From: Martyn White
Sent: 09 April 2019 17:55
To: Planning.Responses
Subject: FW: CM/6/19/HH & CM/7/19/L

CM/6/19/HH & CM/7/19/L

The Climping Mill site comprises a number of buildings which reflect its various past uses including residential, educational, and agricultural. Of note is the main listed Building (Climping Mill), Mil Thatch and Mill Cottage. The application relates to Mill Cottage which sits to the south west of the Mill and is a curtilage listed structure. It is a modest building with an 'angled L-shaped' plan form.

Mill Cottage
Ground Floor Plan
As Proposed

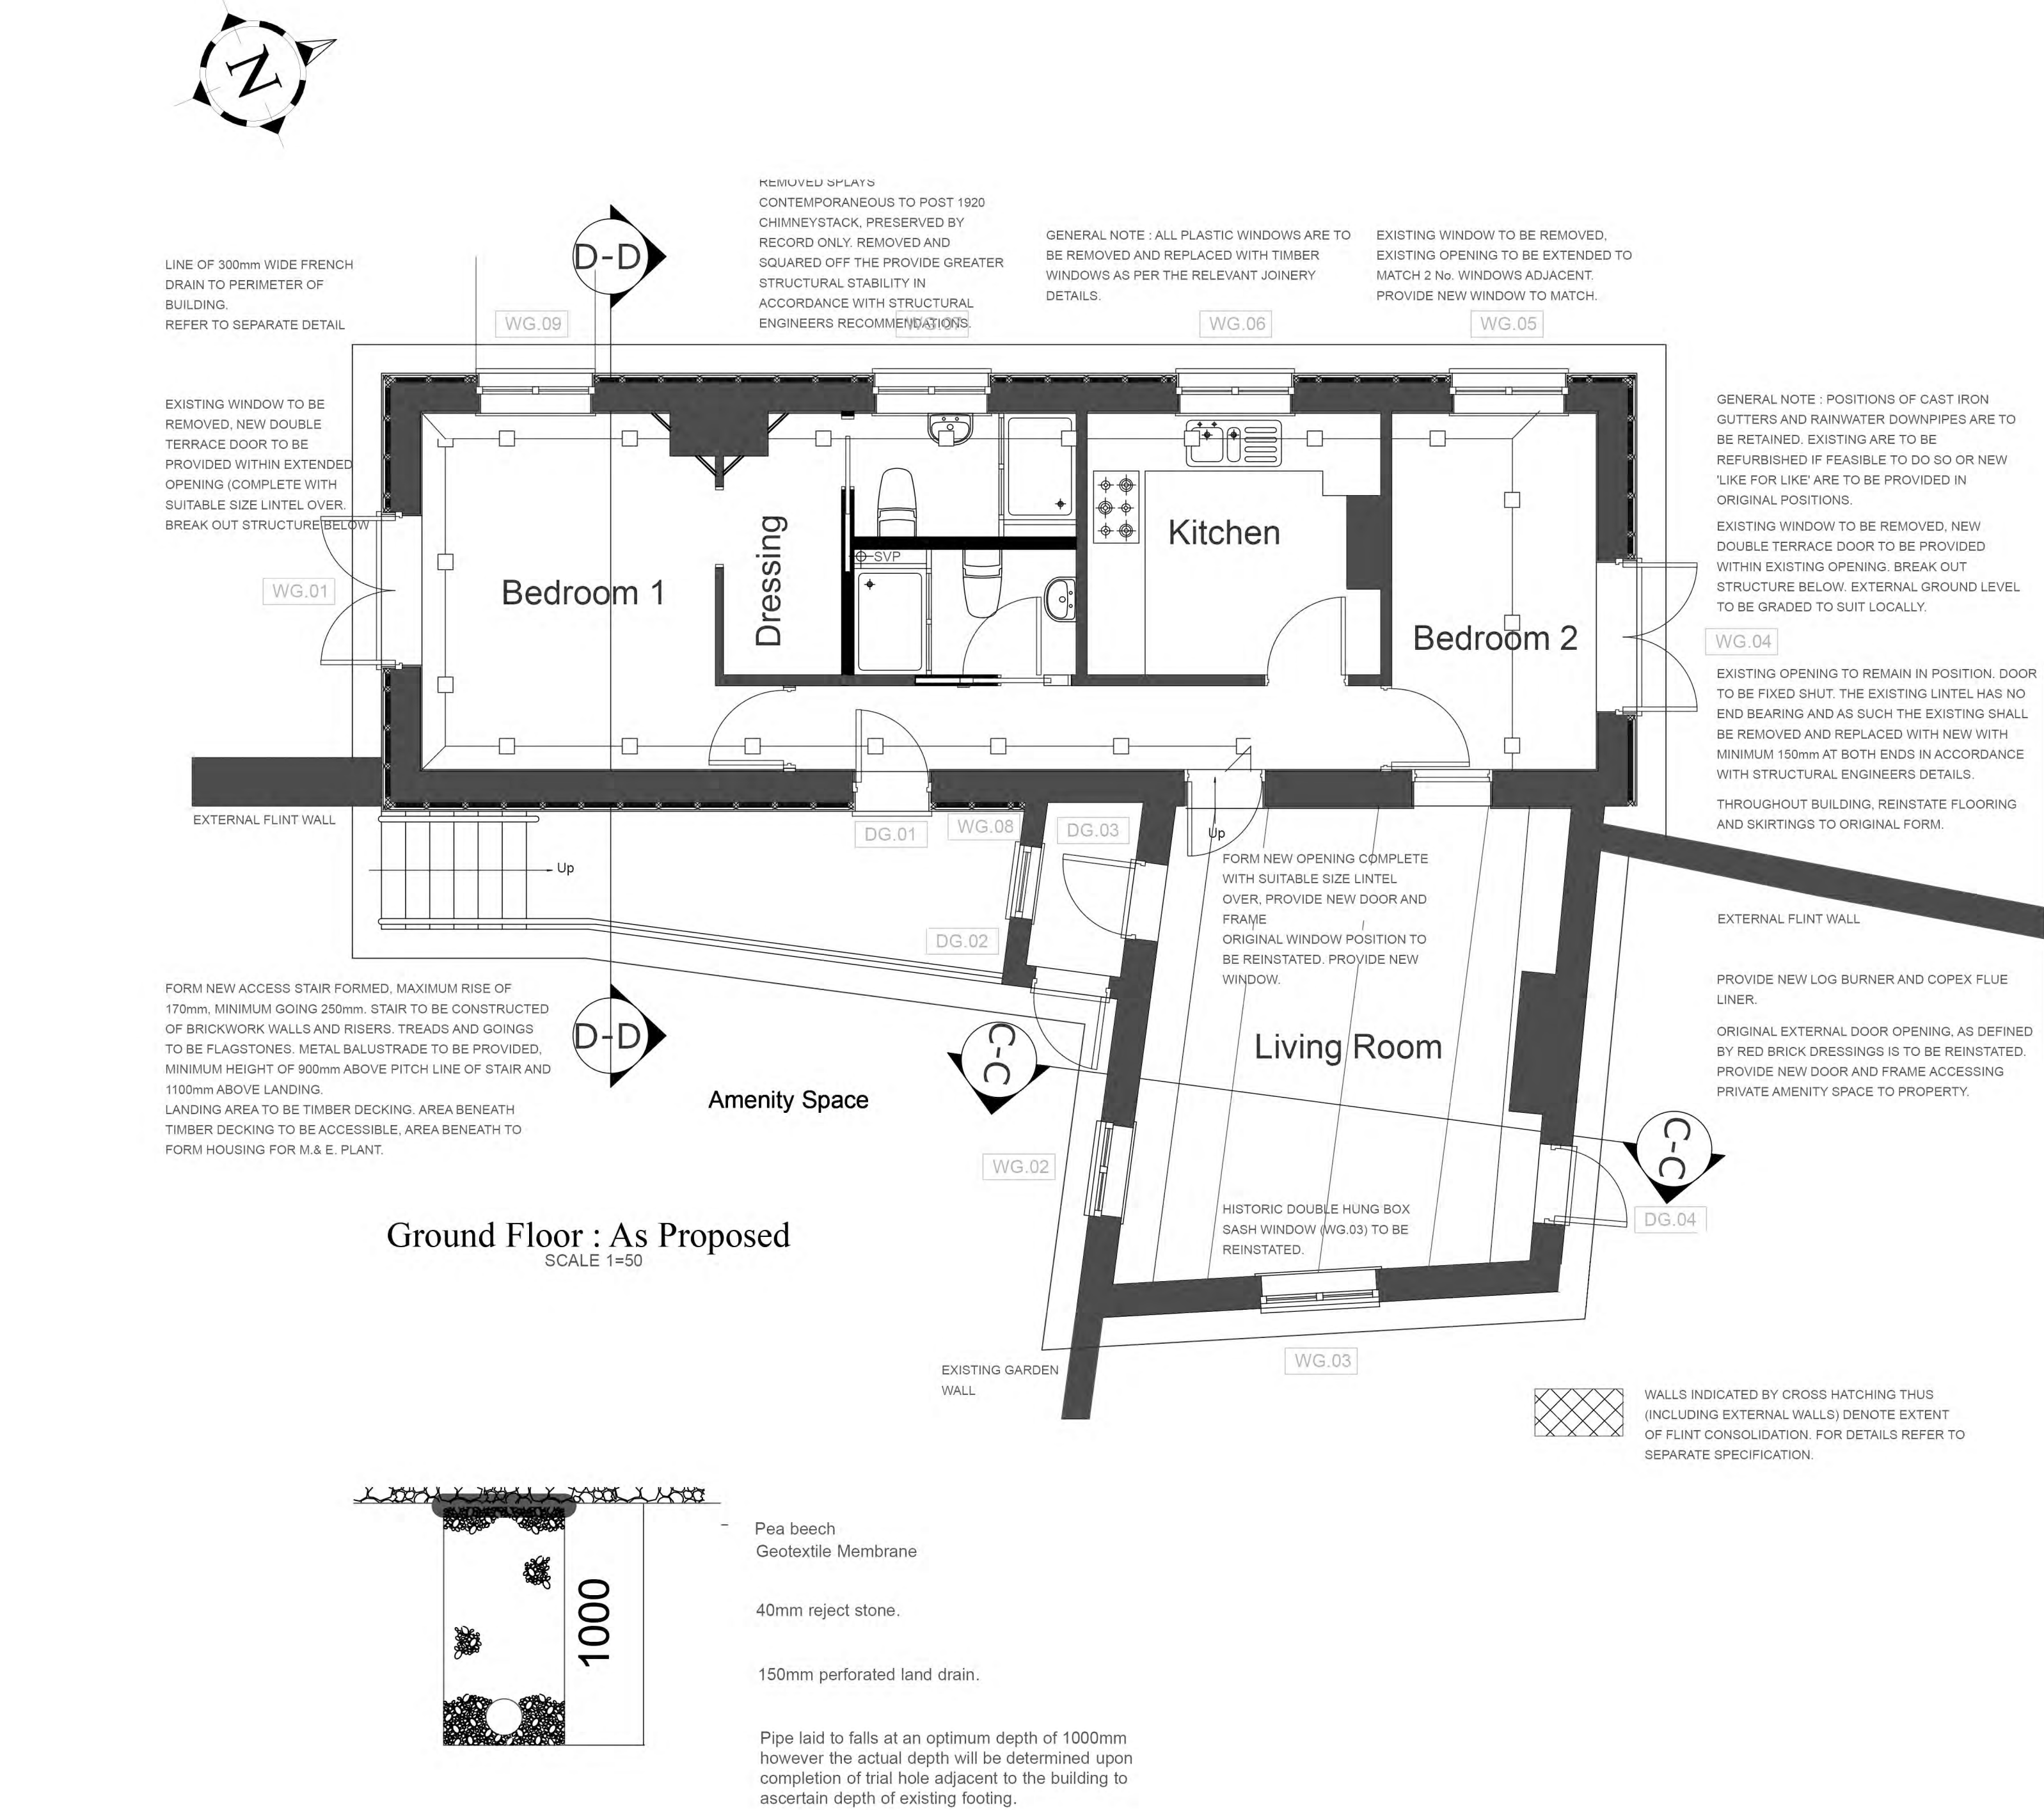
The alteration to the layout of the building is such that it will not harm its character, or result in the loss of any significant amount of historic fabric. Likewise, the loss of what remains of the angular fireplaces will not result in the removal of any significant amount of historic fabric. Such a proposal will allow the internal space to be better used, whilst ensuring that the attractive external chimney can be retained.

Drawing Title
Mill Cottage Elevations As Proposed

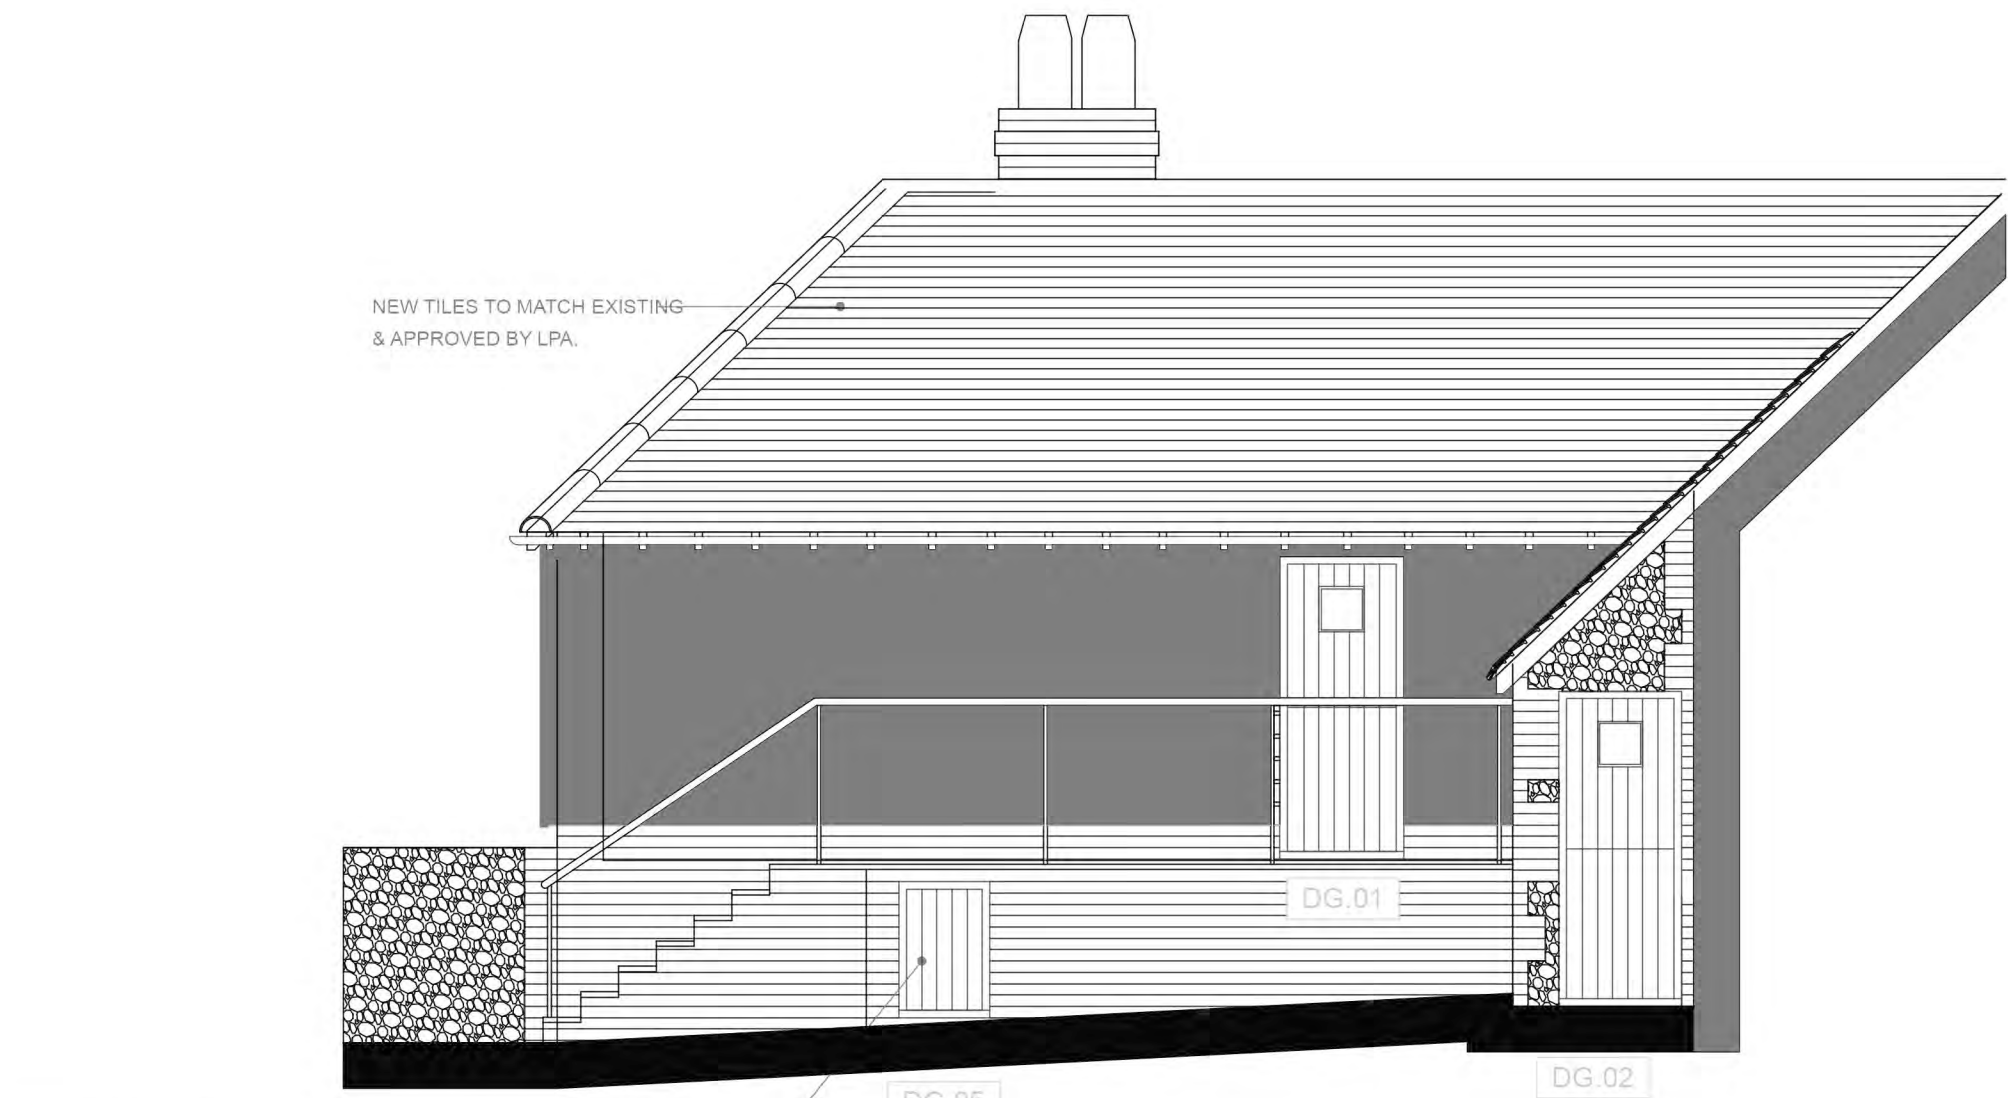
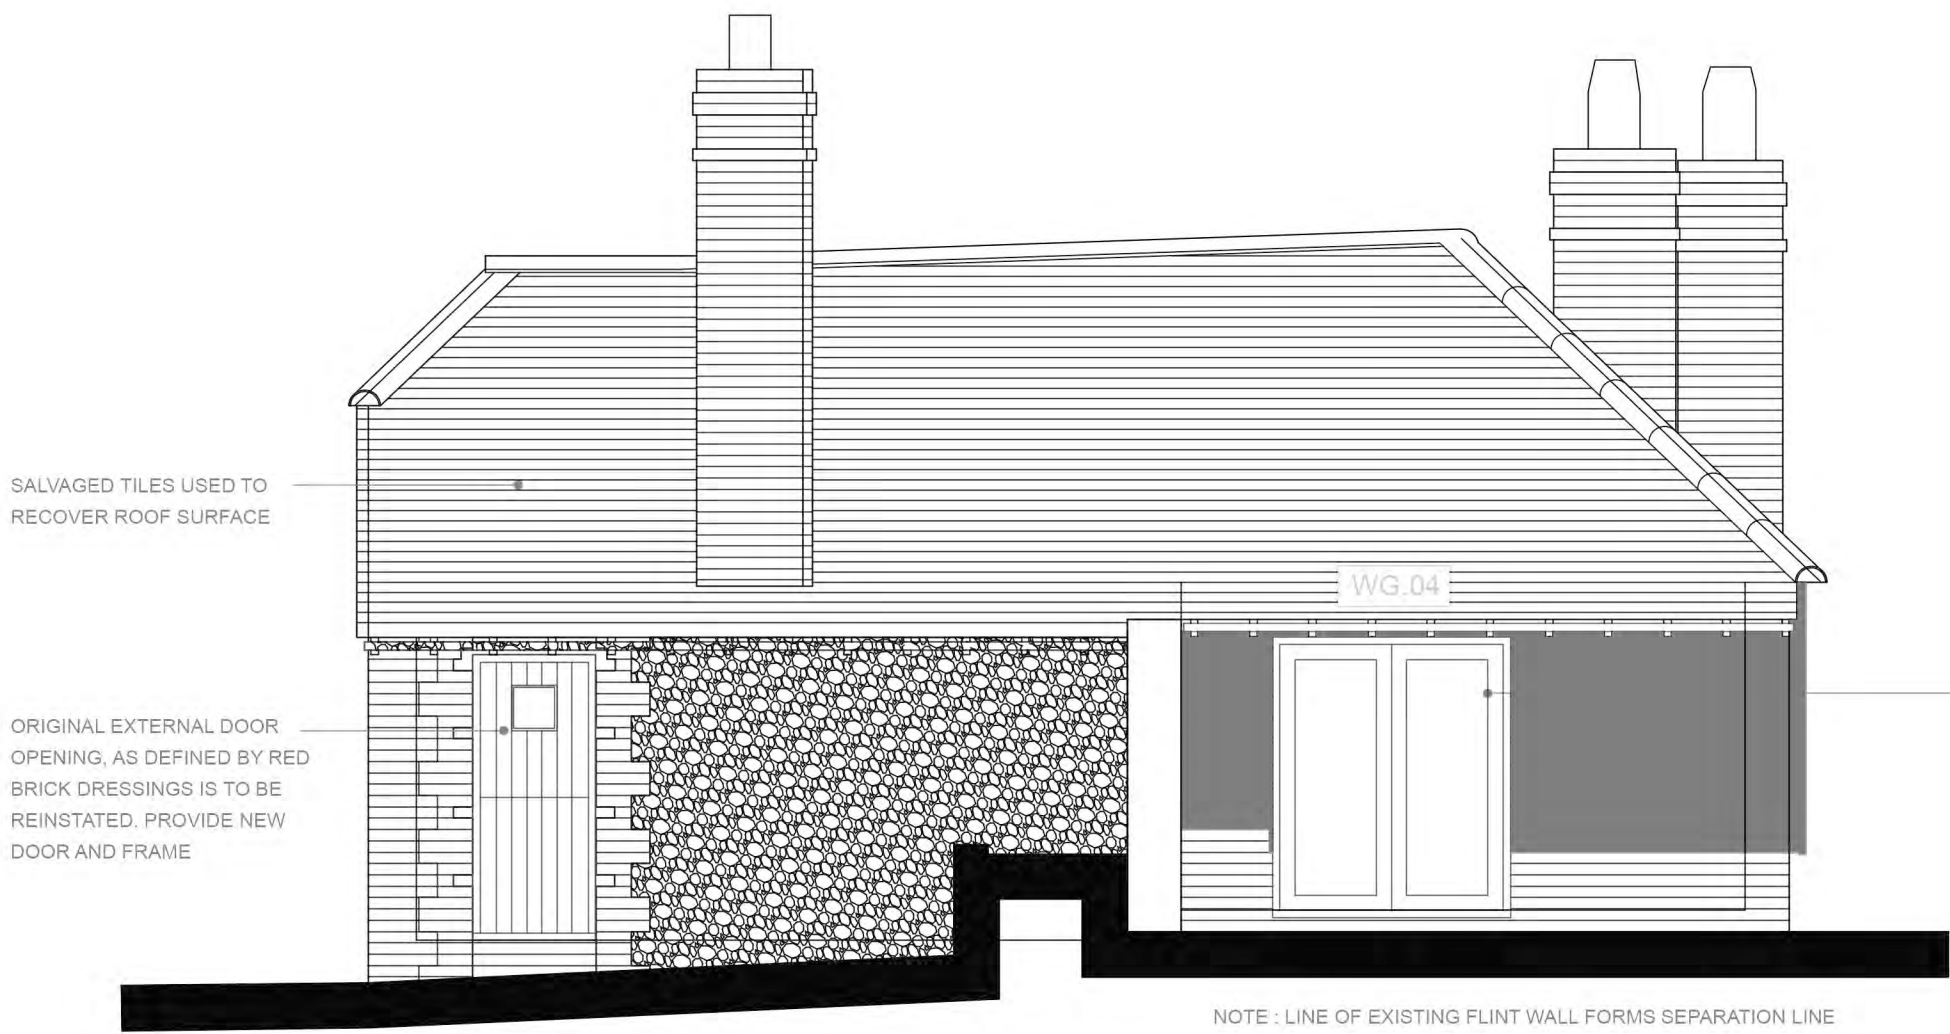
I note that the application seeks to introduce new windows and doors which are more in keeping with the appearance of the property. Such a proposal can be supported, subject to details of their design.

Further, the introduction of additional windows will not harm the character of the building, and their openings will be incorporated into the new cladding proposed. As I am unable to see the details of the windows and doors, they will need to be provided for by way of condition.

The use of the proposed cladding will cover those parts of the building which have the later, more modern brick work. Such a proposal will enable the building to better relate to the main listed building, which bears a similar characteristic.

If minded to approve this application, please provide details of the doors and window by way of condition, as well as details of the decking and the proposed railing. Please also request that the submission of details related to paint/stain colours for the external elevations.
